Planning Application Ref: A/38/18/RES

Location: Manor Nursery, High Street, Angmering

Description of works: Approval of reserved matters following outline consent A/51/14/OUT relating to appearance, landscaping, layout & scale for demolition of the existing Manor Nursery Garden Centre & hard standing & redevelopment for 32No. dwellings with associated access, public open space & landscaping

Tree Retention and Protection Plan - Sheet 01
Manor Nursery, Angmering, West Sussex

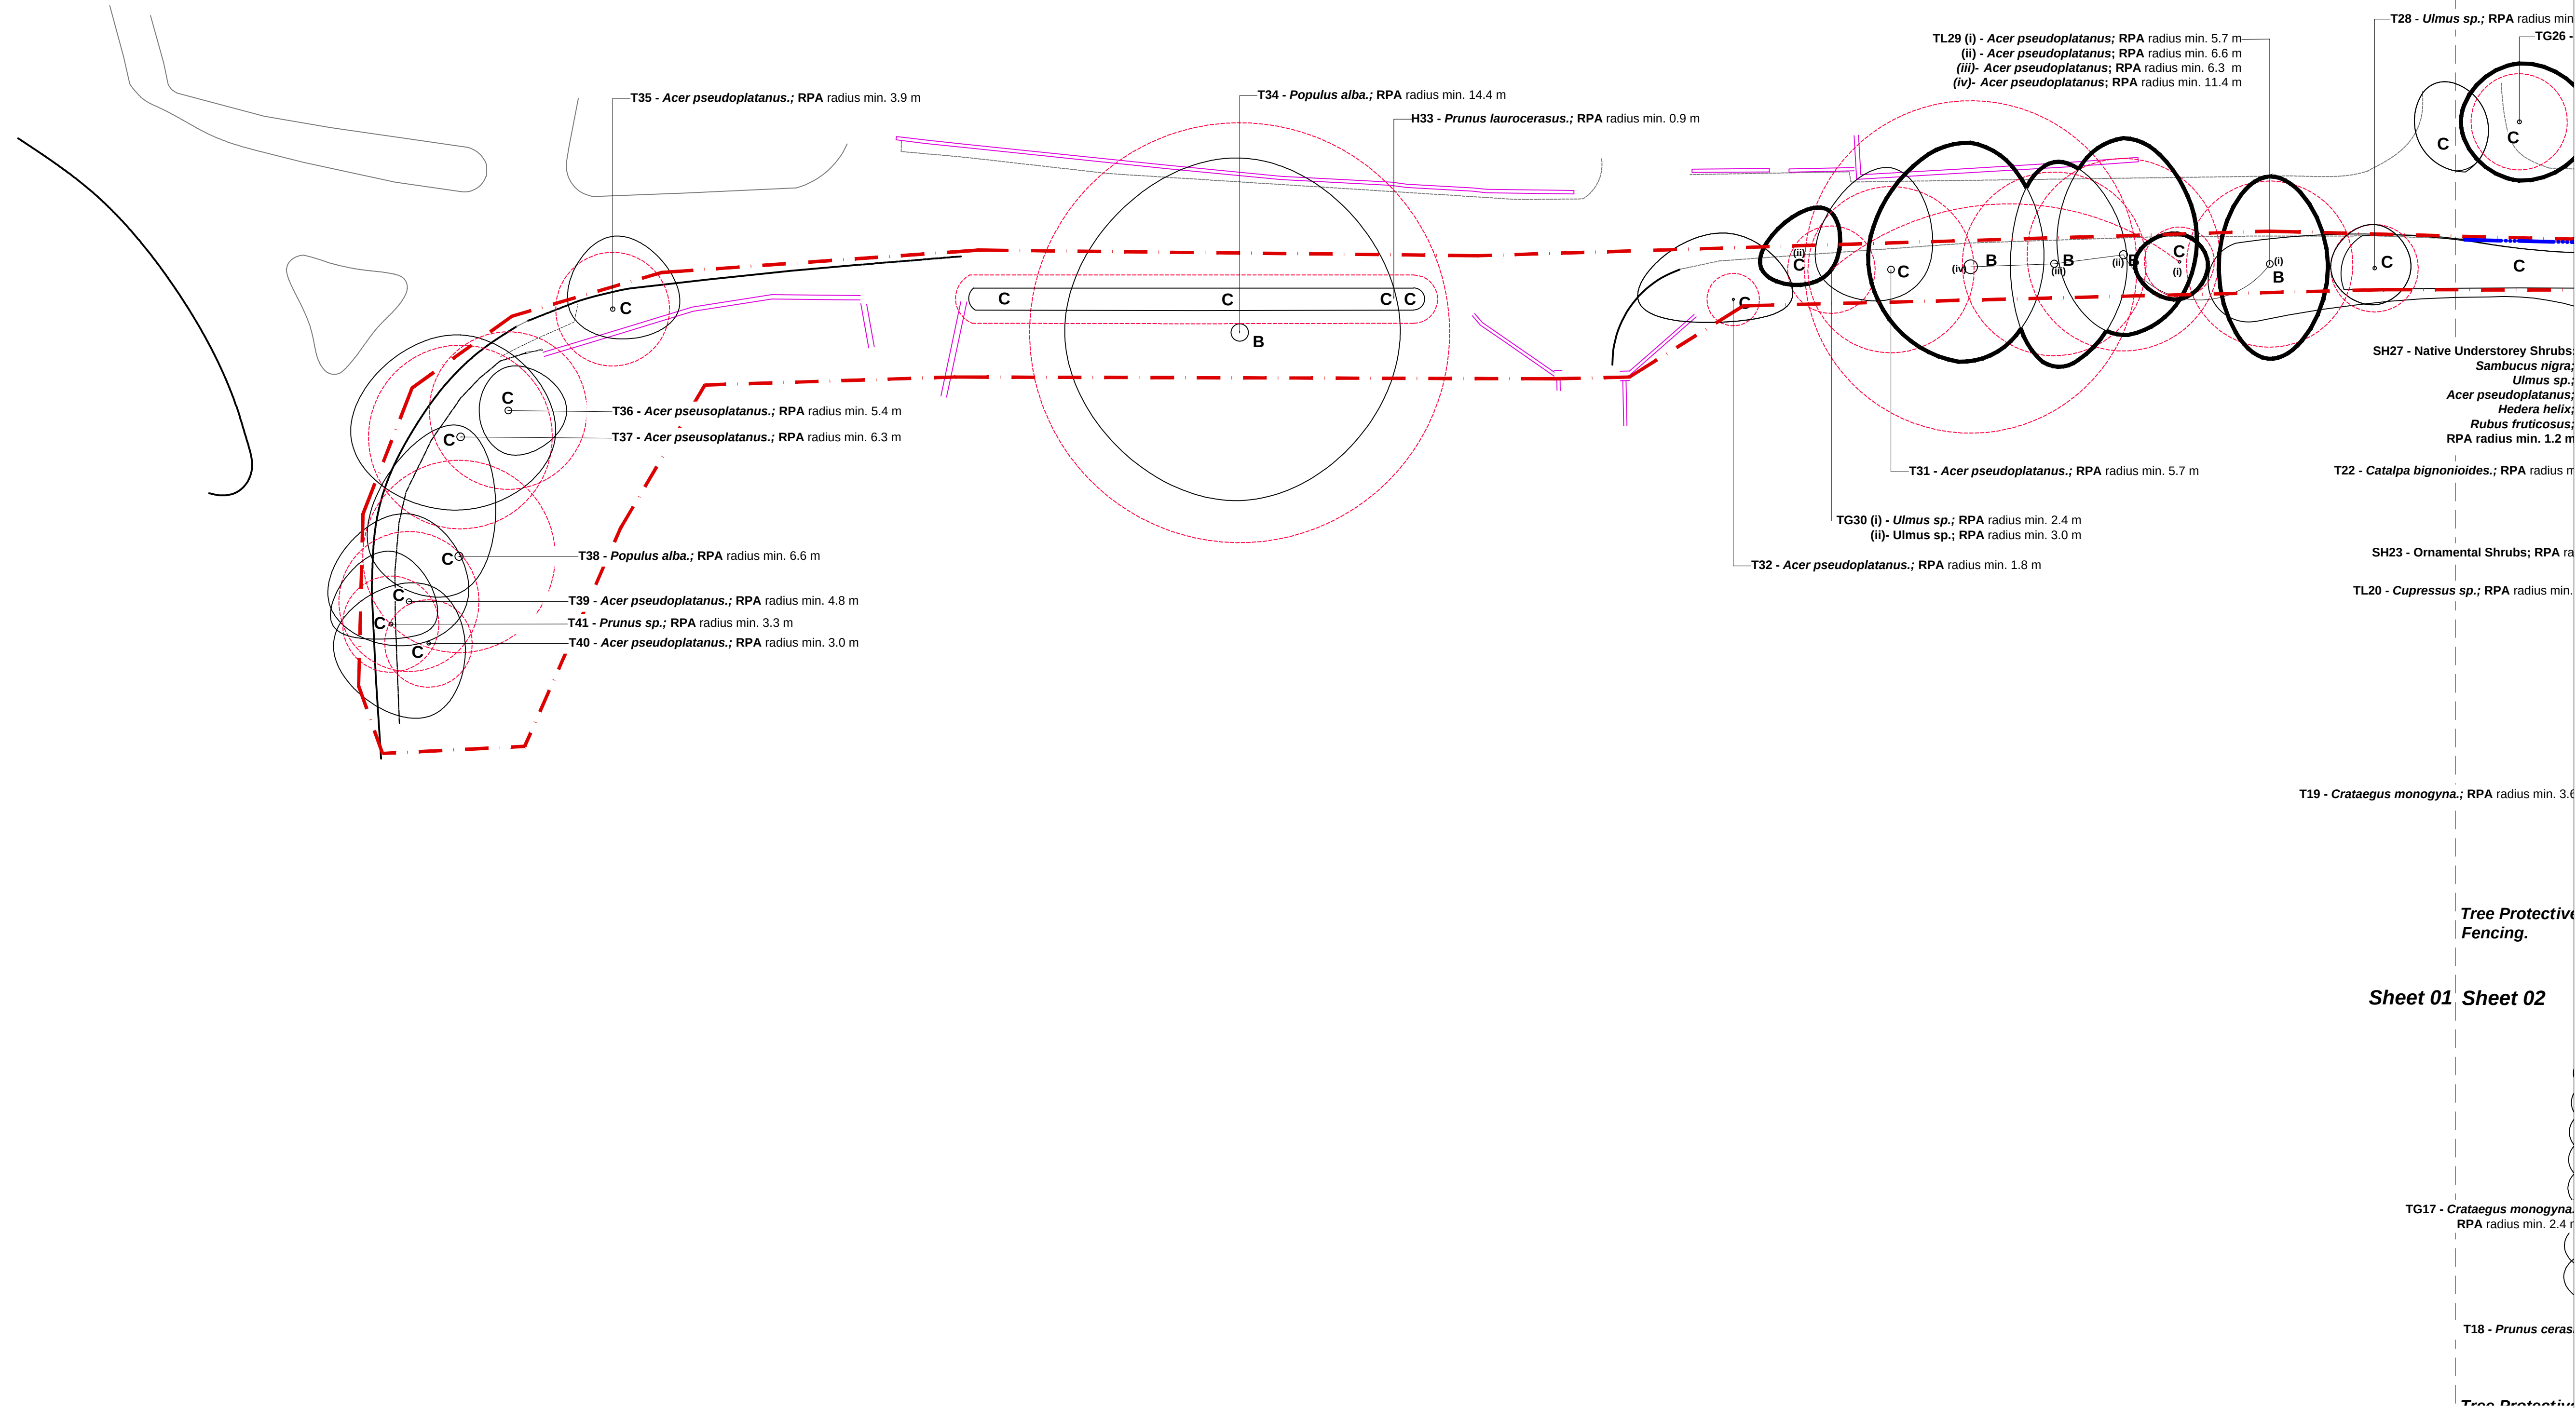
- The previous request for a Tree Protection Plan (TPP) which adequately respects this important tree has been met in part, but remains open to interpretation which is unsatisfactory.

- The fencing must be ‘fit for purpose’ and form an effective Construction Exclusion Zone (CEZ) around the RPA which overlaps the development. Any planned incursion into the CEZ for the purpose of removing hard standing must be undertaken in full accordance with existing conditions, namely the advance approval of the Local Planning Authority and preferably under supervision of the project Arboriculturist.

- The TPP (dwg.no LLD1275-ARB-DWG-002, Rev 03) must now be revised to clearly show the line (legend - bold blue) of protective fencing outside of the RPA of T07 and other retained tree RPAs which overlap the development.
